Rezoning Transportation Analysis

Petition Number: 2023-013

Date	Description
05-24-2023	First Review (PDM)
07-28-2023	Second Review (PDM)

**RZ.01**

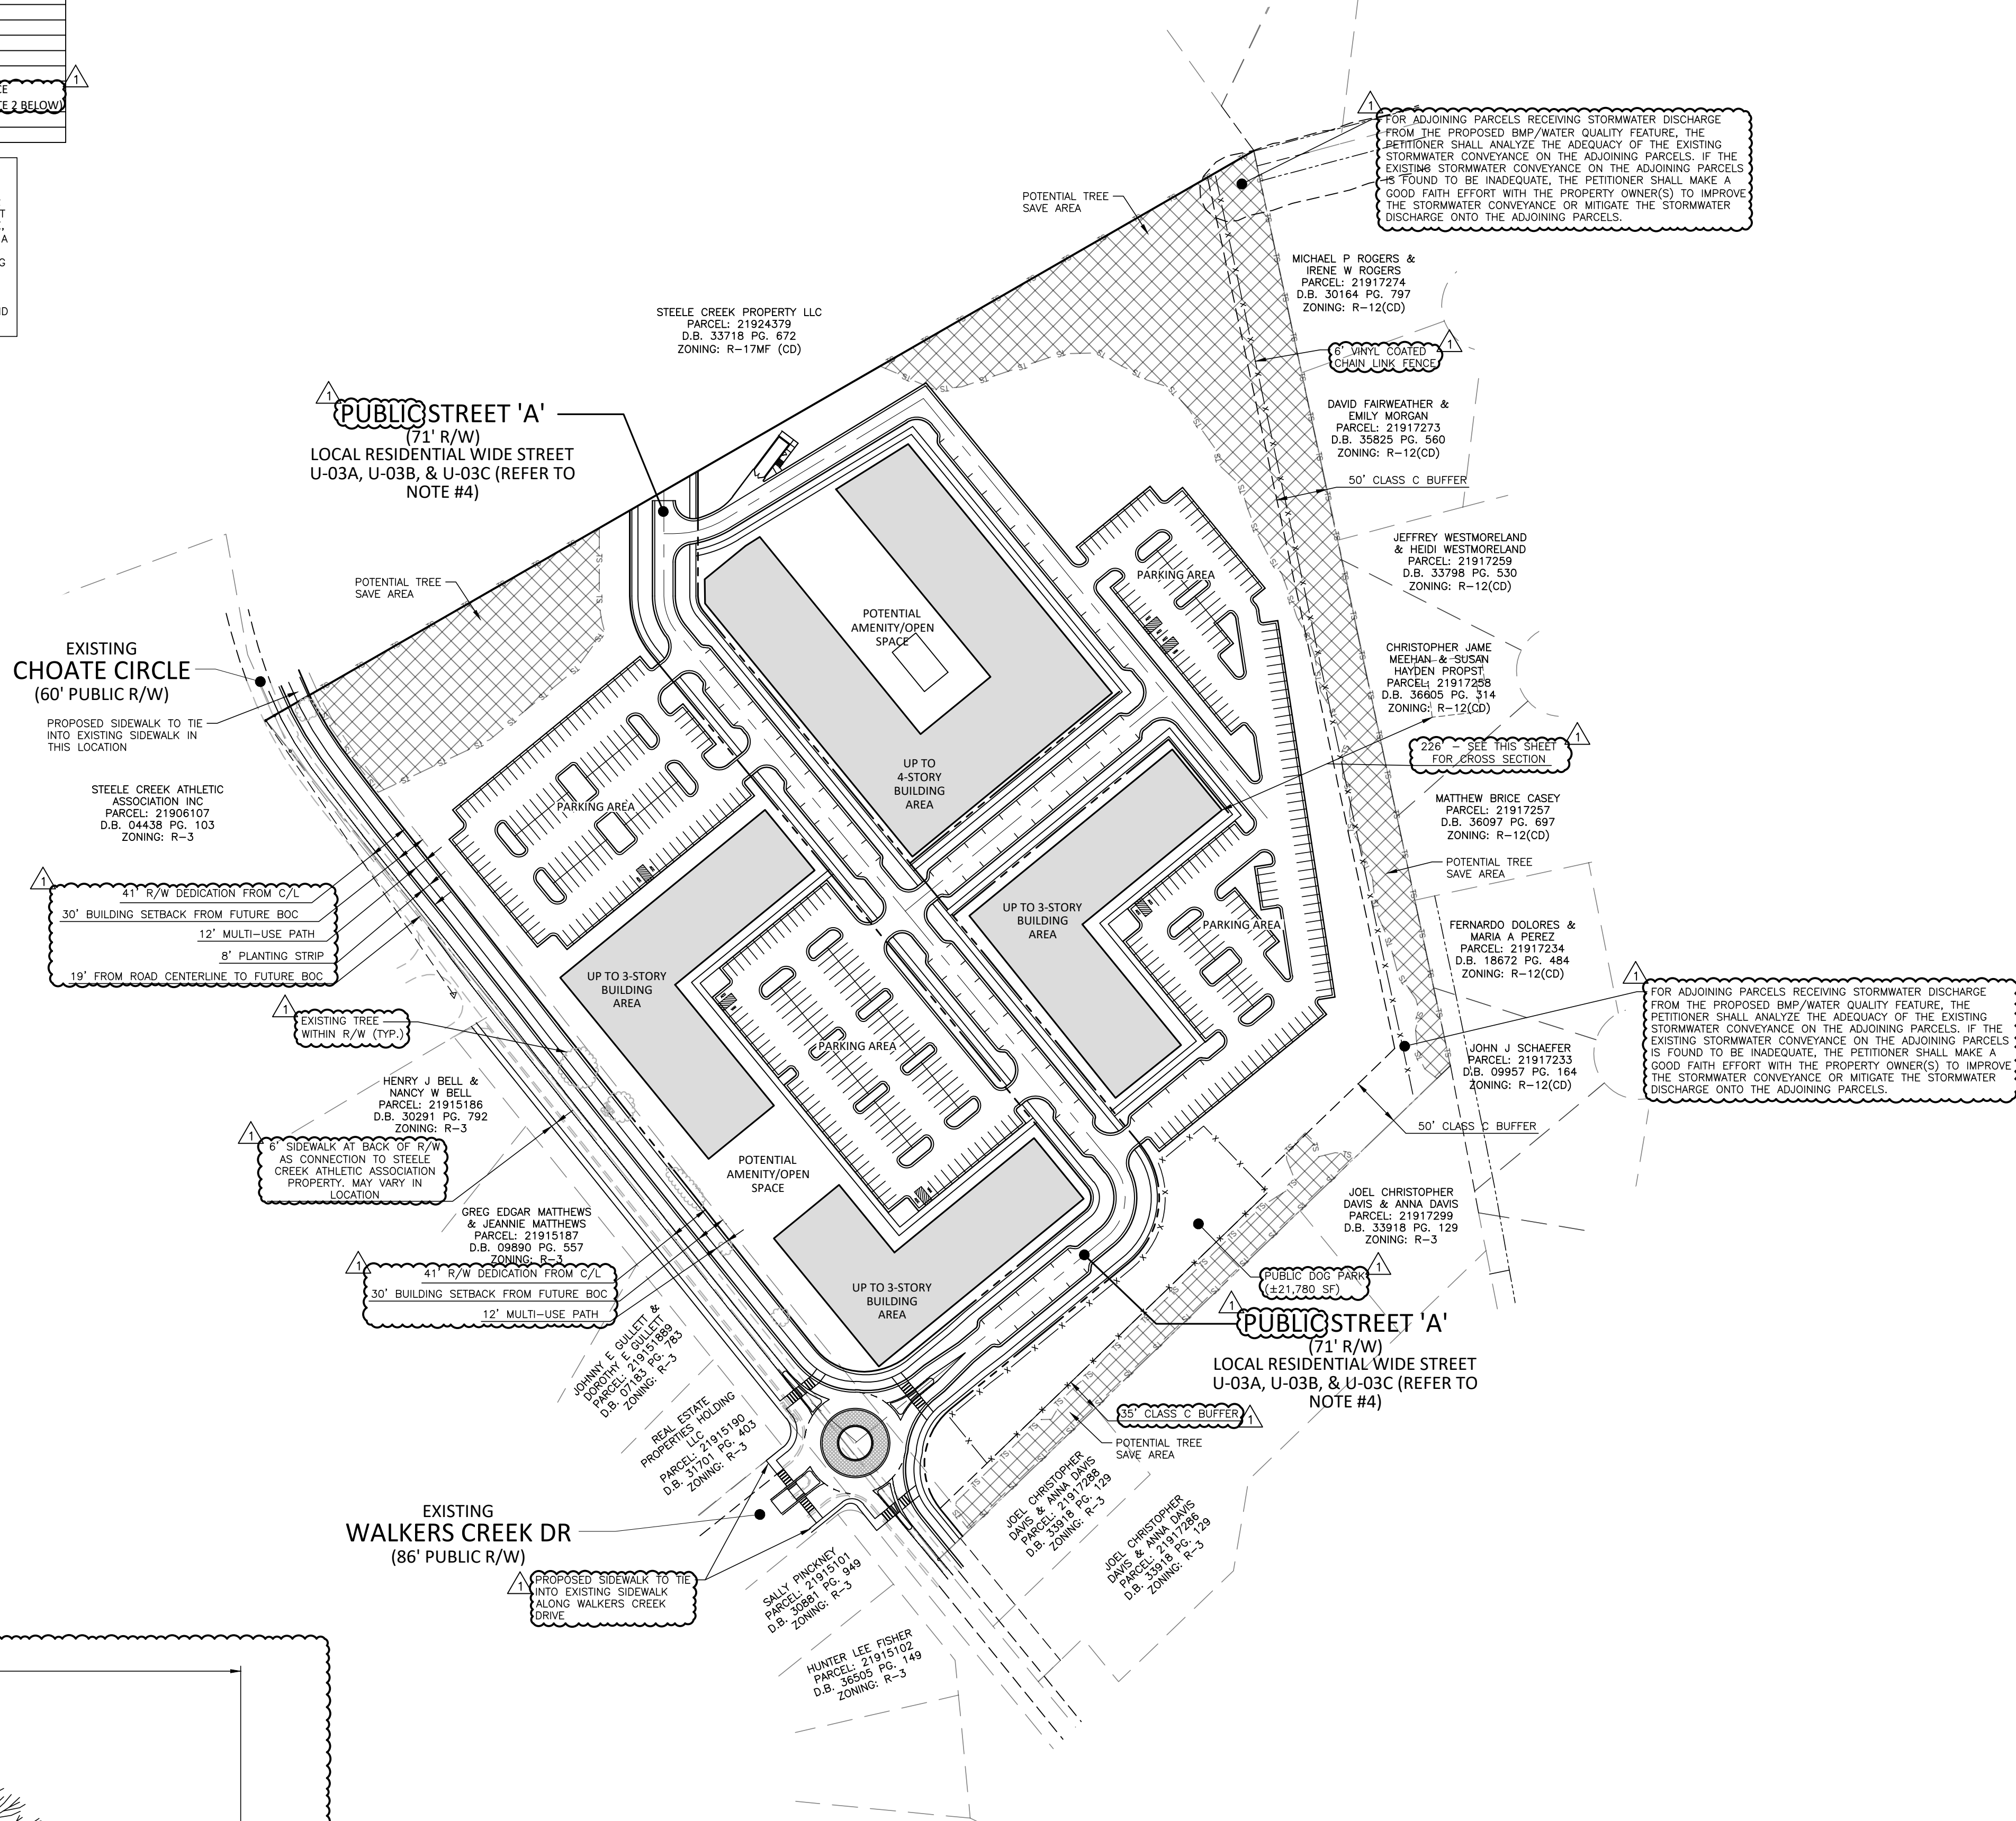
1. ~~Curbline:~~

~~**Choate Circle:** Location of curb and gutter to be installed a minimum of 19 feet from roadway centerline to accommodate the Charlotte Streets Map with a roadway typical section of a 2+ Avenue.~~

~~NOTE: Additional distance from center line to back of curb may be required in locations where a median is present or around intersections and interchanges.~~

~~Label and dimension the curb and gutter from the centerline for each road on the site plan.~~

4. ~~Revise site plan and conditional note(s) to commit to dedicate a minimum of 35 feet of right of way from the road centerline on Choate Circle. The site plan shall label and dimension the right-of-way from the road centerline. Provide SUE for multi-use path if located outside of the ROW.~~
5. **Outstanding Comment from 7.28.2023:** Revise site plan and conditional notes(s) to convert the proposed private streets to public streets.
6. ~~Revise site plan and conditional note(s) to commit to construct bicycle facilities installing a 12' multi-use path and 8' planting strip to meet the Council-adopted Charlotte BIKES Policy. Multi-use paths maintained by the City shall meet ADA/PROWAG requirements.~~
7. ~~Revisit site plan to remove the left turn lane stop bar shown on Choate Circle.~~
